Event Transcript

Project:	Great North Road Solar and Biodiversity Park
Event:	Issue Specific Hearing 3 (ISH3) - Part 1
Date:	4 February 2026

**Visual Receptors -
Scale of Change After Mitigation
Figure 7.7**

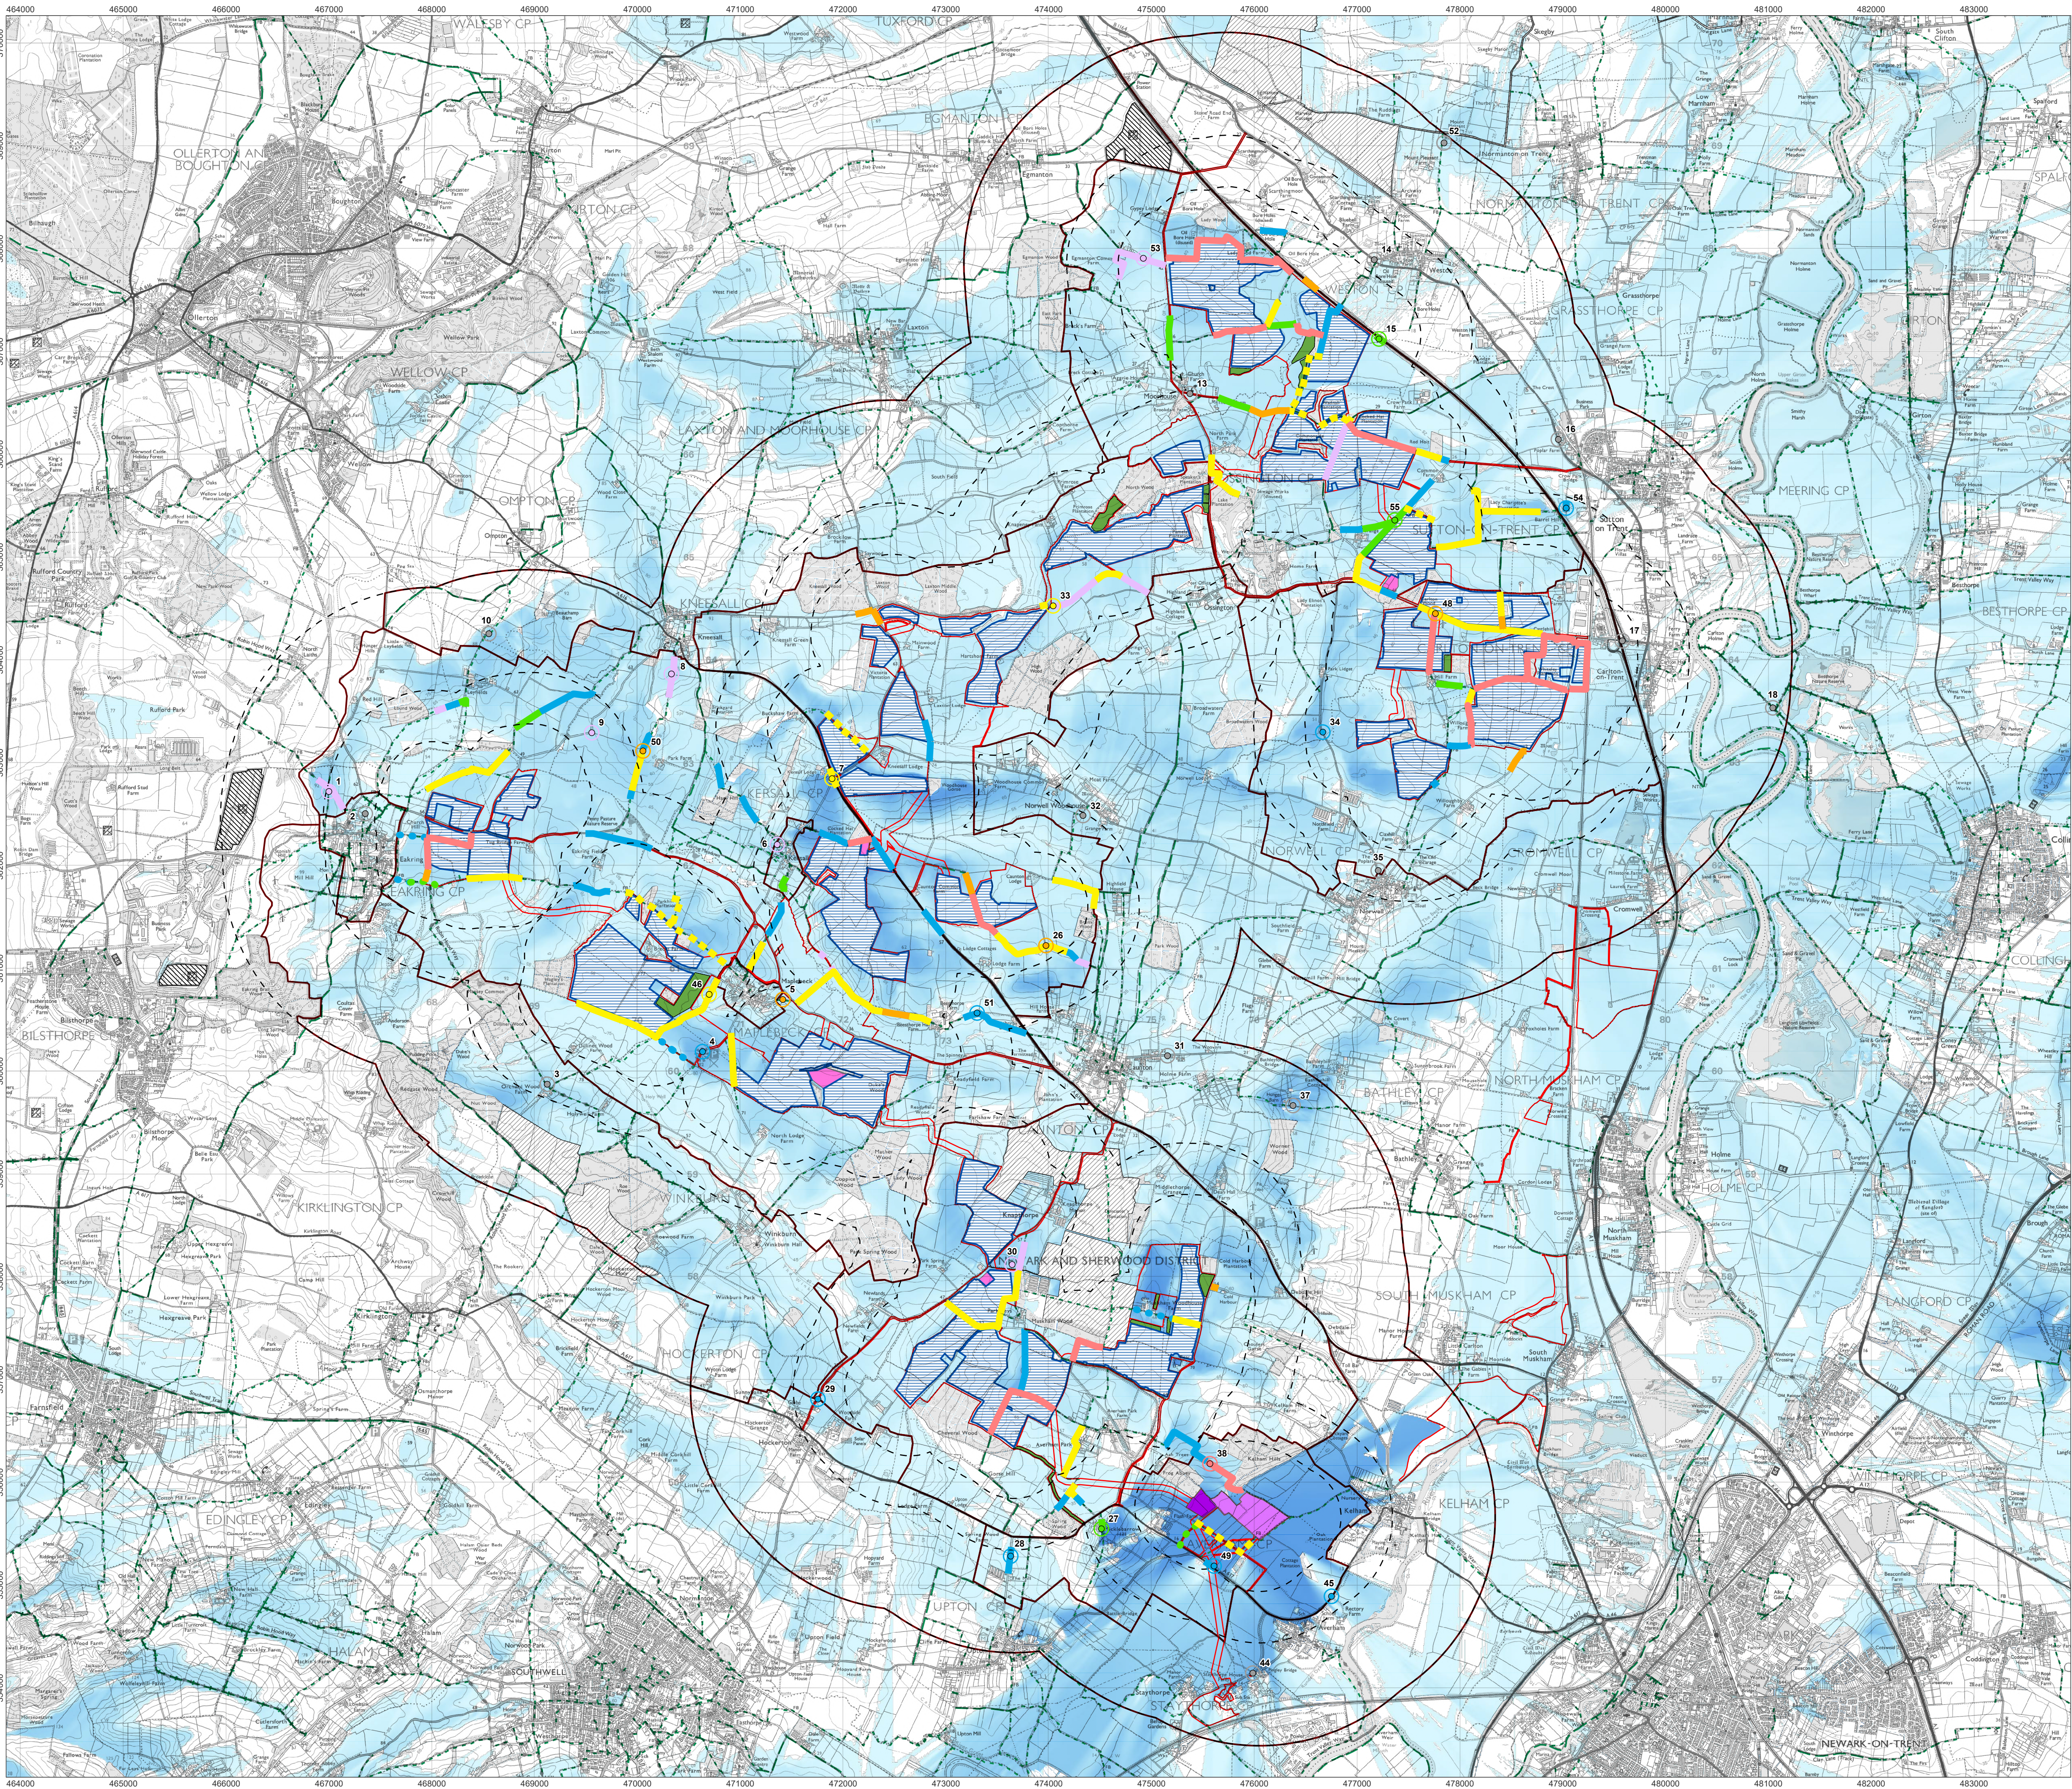
So I was just going to ask if we could run through those particular receptors where moderate effects have been identified, whether there are particular points of concern that the Council has in terms of those. Um, so is that is that. Yes, I think yeah, those are correct. Yeah. So that's the table 7.7. So, um, there are a number of landscape, um, receptors for which moderate effects have been identified. Are you able at this point to identify ones that are of particular concerns to the council?

Yeah. And we have again discussed this right with, with the applicant and helpfully, the applicant supplied, uh, some appendices to the written questions which set out the color code, really the levels of effect across particularly the visual receptors on public rights of way and on, on road users. I. There was a couple of places on those where I think there might be an error, but I think that's just worth a discussion between us outside of this. Um, but going back to the tables are of two locations, as we raised with the applicant at discussions this week were with regard to the Meadowlands LCT.

Um, and with regards to the road users, just into Group E north of Group F on the bit between Ossington Road and Thornton.

Yeah. Well, with regard to the Meadowlands LCT, that's quite a small there pockets of, of, um, landscape character that go through the main host landscape character area. And there's some locations around viewpoint five. Viewpoint 13. This is what we've discussed over the last few days as well, where we consider that some of the although there are limited direct impacts, some of those areas are quite are surrounded quite intensely by solar array. And we consider that the perceptual and experiential experiential impact on the landscape character features warrants it being significant.

And then with regard to the area between Ossington and the AA one, effectively and around the edge of Group E and group F, the applicant does go sort of some way north of that road captured in Group F, but given the sort of openness of the landscape there and the um, degree of solar array in that location and the extent to which it will be experienced, we consider that that just tips a little bit further further north than is currently shown.

Um, I mean, yes, it makes sense. There often is professional disagreement about detail, and that's what this is to a degree. Um, the one thing I just would say is when it is getting written up, the Meadowlands LCT has two moderate judgments, one for construction and early operation and another for after mitigation. So we'd need confirmation about whether you mean both or just one. Other than that, we can firm up the detail and see where we get to.
